## Laurie Leader - RE: BP#2015-00403 131 Johnson Road - Sign permit zoning review

Thanks for clarifying all of my questions about this matter. I've gotten feedback from both my client, 440 Western Avenue LLP, and the signage contractor, Burr Signs. Below are responses to your questions earlier posed to Mason Legendre, which I trust you will find satisfactory:

131 JOHNSON ROAD - Building Signs
 Scale: NTS
 Square Footage: 32

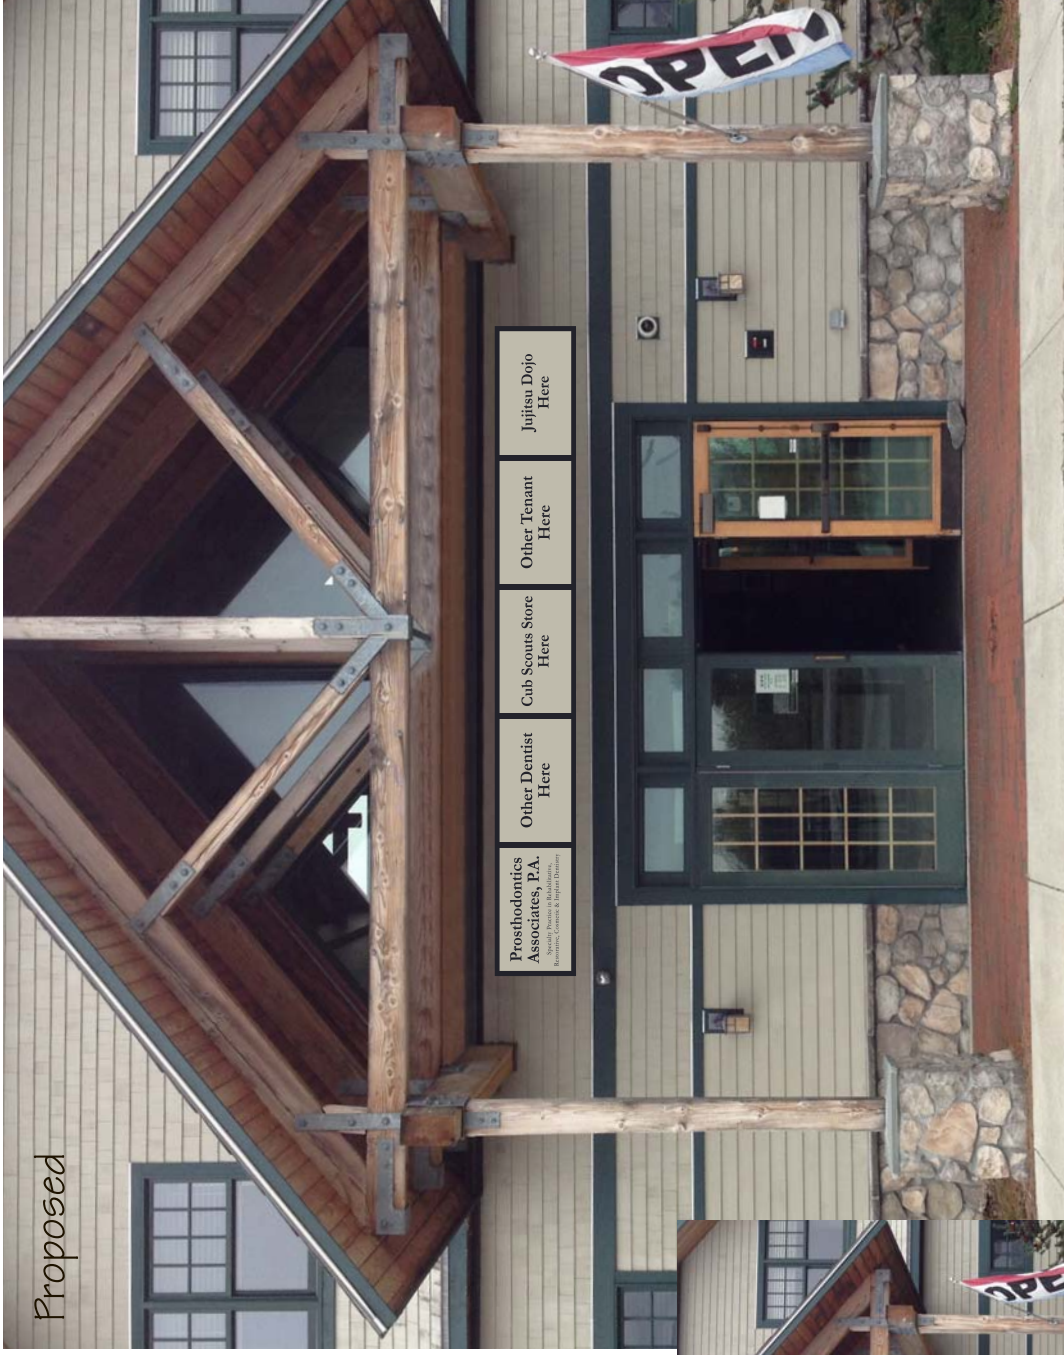
3. The building sign states Jujitsu Dojo here. This is not a permitted use for the building. In order to have this permit approved, the tenant will need a change of use approved prior to this approval. The other option is to leave the sign blank and apply for that sign permit at a later date.

4. Clarify if Prosthodontics Associates, P.A. and Southern Maine Oral & Maxillofacial Surgery are occupying

the same tenant space or completely separate tenancies? Add the second dentist sign on the building sign rather than stating "other dentist here".

RESPONSE: Per our discussion, Stone Coast Jujitsu has already obtained a change of use permit for its tenancy of the building.

RESPONSE: Per our discussion, Prosthodontic Associates and Southern Maine Oral & Maxillofacial Surgery are separate legal entities. They lease separate professional office suites within the building. Attached is an updated building proof showing identifying Southern Maine Oral & Maxillofacial Surgery in lieu of the generic "other dentist here" sign.

131 JOHNSON ROAD - Multi-Tenant Pylon
 Scale: NTS Square Footage: 69

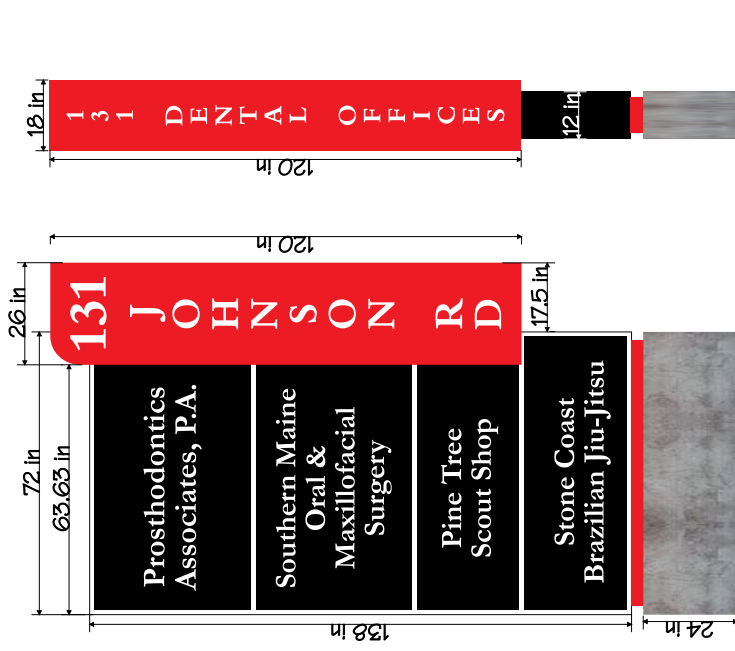
1. The sign must be 5 feet from the property line. It is shown to be 10 feet from the road but does not reference the actual property line. Please revise.

2. When providing calculations for the free standing sign, square footage calculations must include the square footage for the 131 Johnson Road portions of the sign as well. According to my calculations, the sign exceeds the allowable 100 square feet. Please revise to meet allowable zoning.

5. Clarify that the existing sign will be removed.

RESPONSE: The driveway access to 131 Johnson Road is via a right-of-way (and signage easement) over City-owned land that lies between my client's building lot and the City-owned roadway. The plot plan (satellite photo) originally submitted by Burr Signs showed the pylon sign location as 10' from the painted white line marking the edge of the nearest travel lane on Johnson Road. Instead, the location will be no closer than 5' from the edge of Johnson Road, where curve of the driveway ends at Johnson Road. This different measurement defines the same location as shown on the original plot plan. However, Burr Signs notes that field conditions suitable for the sign foundation may dictate that the sign be moved several feet perpendicular to and further away from the edge of Johnson Road, towards the location of the existing sign. In no event will the sign be placed closer than 5' from Johnson Road.

RESPONSE: Per our discussion, you have recalculated the signage area on the pylon proof and found it complies with the 100 SF limitation of the signage ordinance. This is true regardless whether the calculation is just the 69 SF of the advertising panels themselves, or also includes the address area (which my client contends should not be counted as signage area because the address is required by the Fire Department for public safety purposes).

RESPONSE: Burr Signs will remove entirely the existing sign at the time of its construction of the replacement sign.
